Ann Machado - Permit #2013-01624 - 10' x 10' shed

From: Ann Machado
To: kpm@maine.rr.com
Date: 7/30/2013 3:30 PM
Subject: Permit #2013-01624 - 10' x 10' shed

PLOT PLAN
12 CRANSTON ST
REVISED 8/12/13

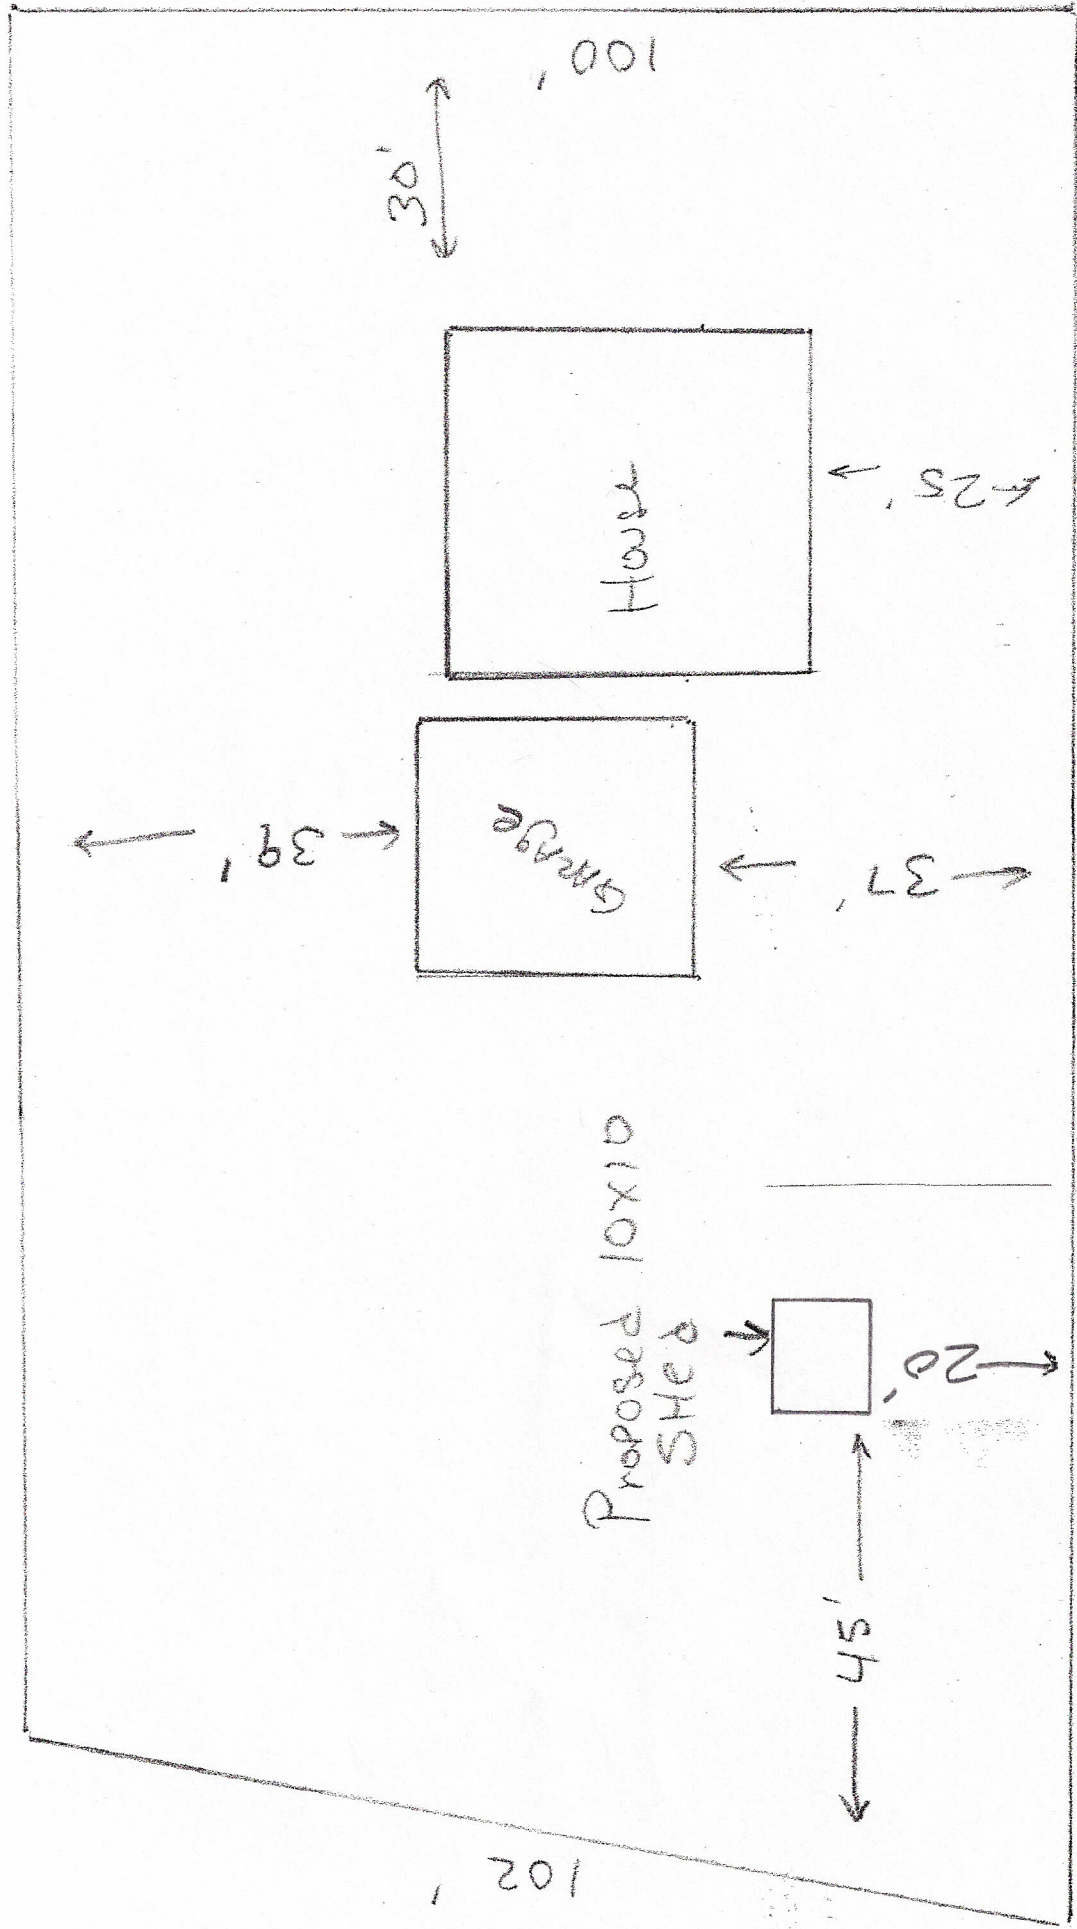
I was reviewing your permit for zoning and I cannot sign off on it. On your plot plan you show a 16' setback from the property line. This is your front property line, so it must meet the minimum 20' front setback [section 14-120 (a)(4)(a)] for the R-5 zone.

You can email me a revised pdf showing the proposed location meeting the 20' front setback.
